M42 Junction 6 Development Consent Order Scheme Number TR010027

8.35 Applicant's Response to Local Impact Report: Solihull Metropolitan Borough Council

Version	Date	Status of Version
1	July 2019	Submitted for Deadline 3

Drawing Title  
**FIGURE 8.3 PROPOSED LANDSCAPE PLANTING SHEET 1 OF 3**

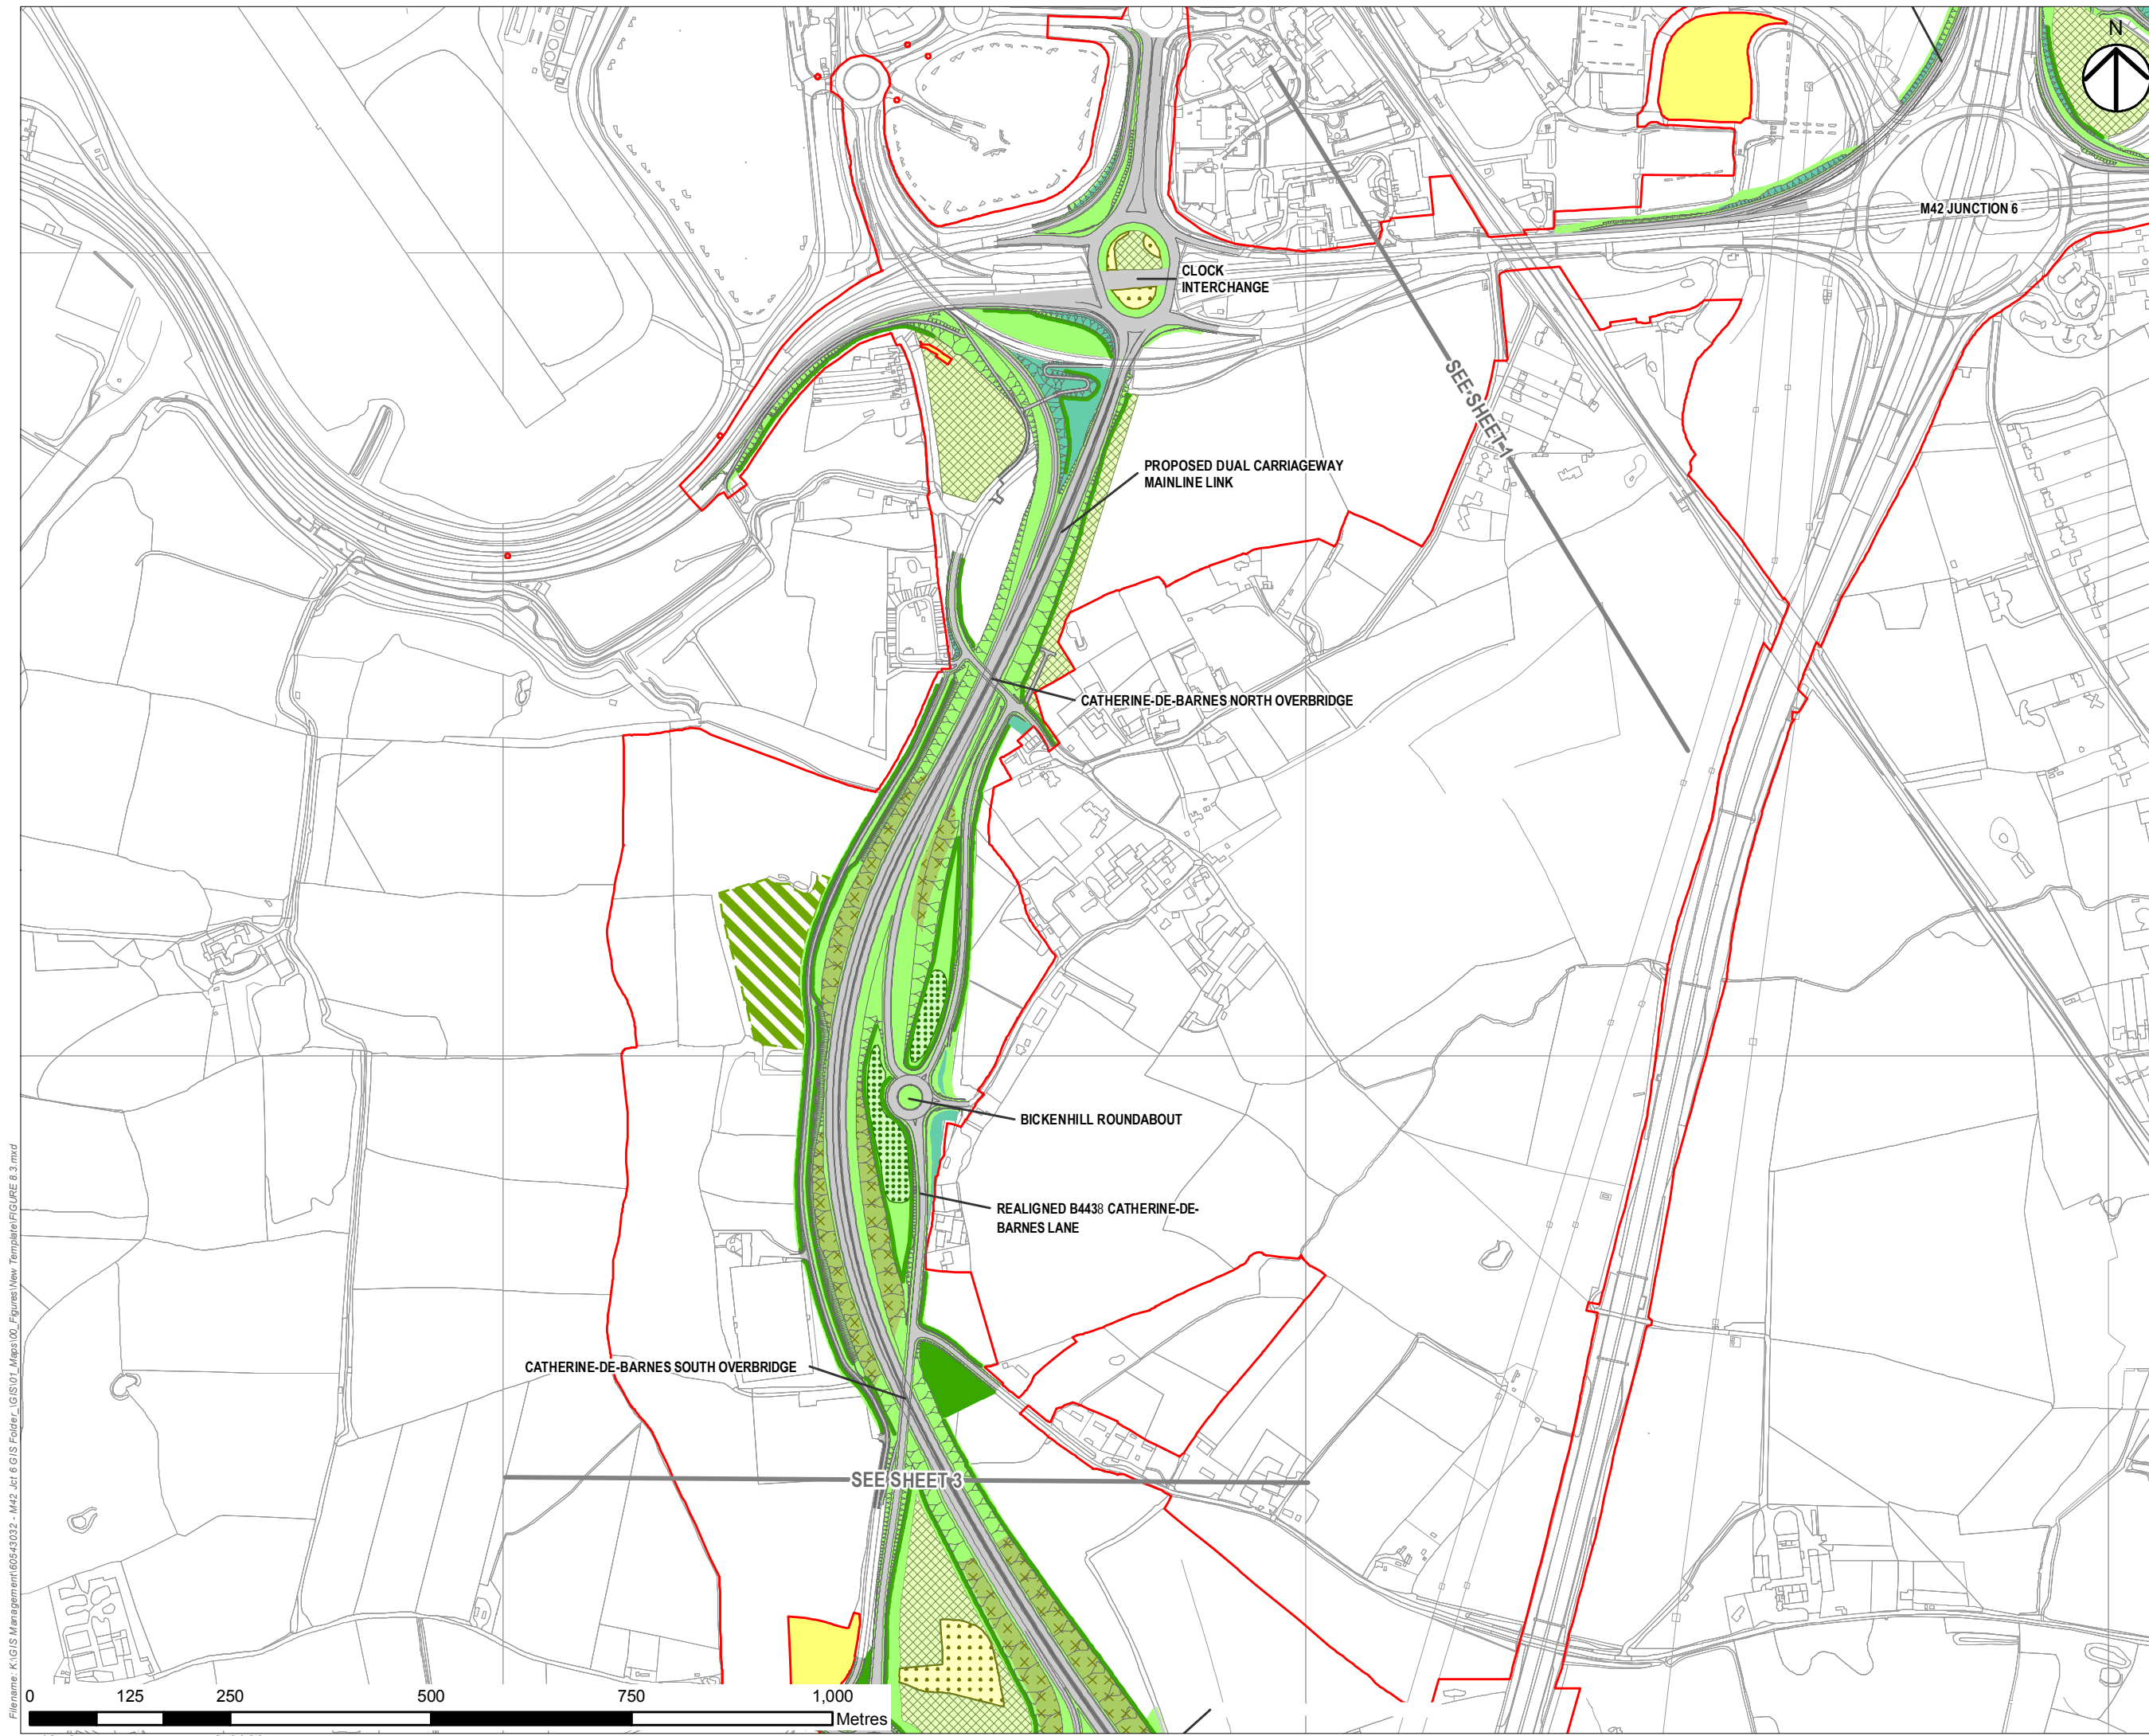
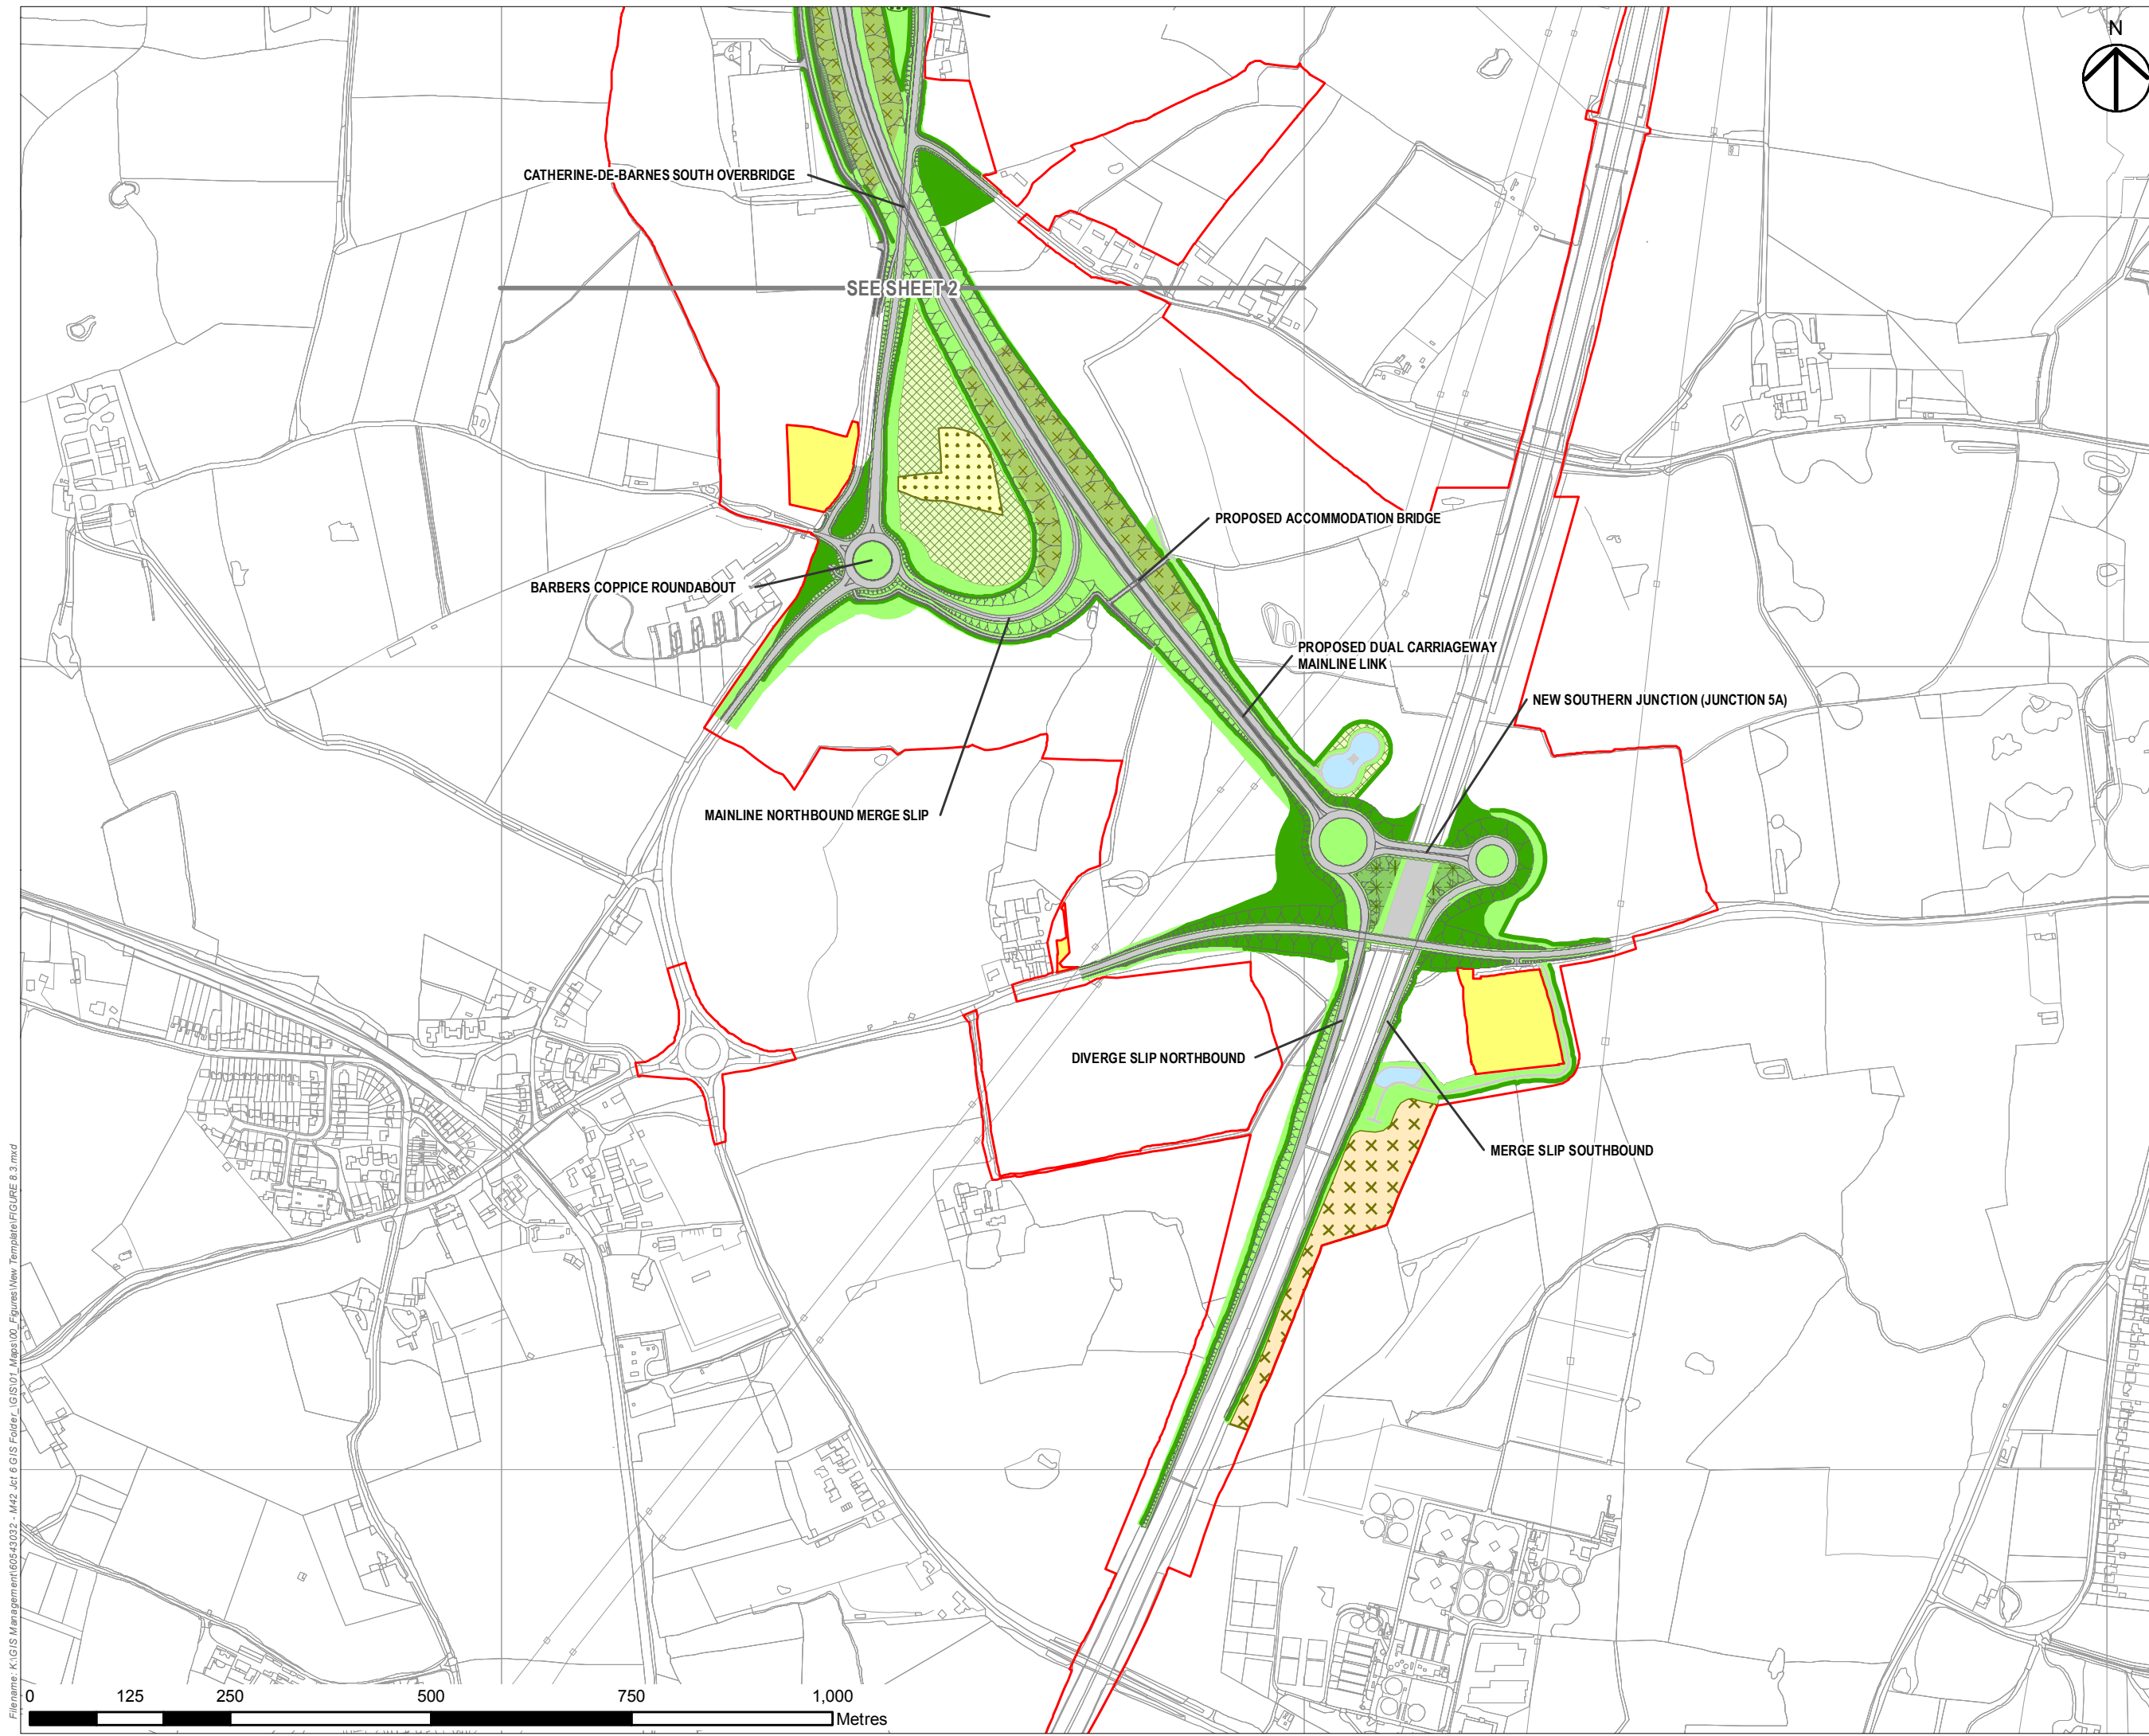
Ref	SMBC LIR Comment	Highways England Response
	<p>Design, Mitigation and Enhancement Measures</p> <p>Compensation</p> <p>The Council's Landscape Architect is satisfied with the proposed embedded and standard mitigation measures, and the compensation measures, identified within the submitted documents. However, further requests that these works also accommodate the principles adopted with the Council's European Regional Development Fund (ERDF) 'Wildlife Ways' Project have been made. Catherine De Barnes Lane, a key corridor within the scheme has been omitted from the Council's programme of works in light of the highway proposals identified within the DCO proposal. The aim of the Council's Wildlife Ways project is to contribute to the specific objectives set out in the European Structural and Investment Funds operational programme to preserve and protect the environment and promote resource efficiency and to undertake a wide range of habitat and nature improvement projects across large areas of the Borough.</p> <p>The Council's Landscape Architect welcomes the proposed mitigation measures and understands the planting strategy and landscaping scheme have been informed by the outcomes of the biodiversity assessment "<i>a key objective being to identify measures that, wherever possible, provide a combined function of landscape integration and/or screening, and habitat creation and replacement, to mitigate effects on biodiversity interest</i>". However, in light of CAP 772 and, notwithstanding any potential restrictions on the proposed landscape planting or landscape strategy by Birmingham Airport's safeguarding zone, the Council have requested whether there is a species list to support the landscape strategy or proposed landscape</p>	<p>The Applicant can confirm it has considered the documents provided by SMBC with regards to the Wildlife Ways in developing the Scheme's landscape mitigation strategy and the Environmental Masterplan as presented within Figure 8.3 and Figure 8.8 of Volume 2 of the Environmental Statement [APP-090/Volume 6.3; APP-095/Volume 6.3]. However, as noted by SMBC, the Applicant agrees there is a degree of incompatibility between the Wildlife Way of Catherine-de-Barnes Lane and the DCO application.</p> <p>The Applicant can confirm that an outline species list is being developed to inform the detailed design of the Scheme. Working drafts of these lists will either be shared with SMBC and the ExA (if the ExA considered this is to be of assistance) during the examination of the DCO application, or will be incorporated into the Outline BMP to be submitted to the ExA.</p> <p>The Applicant can confirm that the outline species list noted above will take into consideration (where appropriate) the wider Warwickshire Arden Landscape and the applicable defined 'Enhancement Zones' within Warwickshire Landscape Guidelines for Arden adopted SPG.</p>

Ref	SMBC LIR Comment	Highways England Response
	<p>planting in Figure 8.3 [TR010027/APP/6.2]. The Council needs to be assured that the planting proposals respond to other adopted Solihull MBC Policies regarding the protection and enhancement of the natural environment, landscape character and local distinctiveness. The applicant has not provided a response on this matter.</p> <p>The Council is mindful of the necessity for wildlife management on and within the proximity of the airfield and indeed Birmingham Airports Obstacle Limitation Surface (OLS), but the Airport's safeguarding zone, a 13km radius of the aerodrome includes the majority of the Borough and the Council would like to be assured that planting proposals respond to those species identified as characteristic of the wider Warwickshire Arden Landscape. Furthermore, part of the site falls within an 'Enhancement zone' (Warwickshire Landscape Guidelines for Arden adopted SPG) where the structure and character of the landscape is in decline. These areas termed 'Enhancement zones' represent priority areas where resources for landscape and habitat restoration should be targeted.</p>
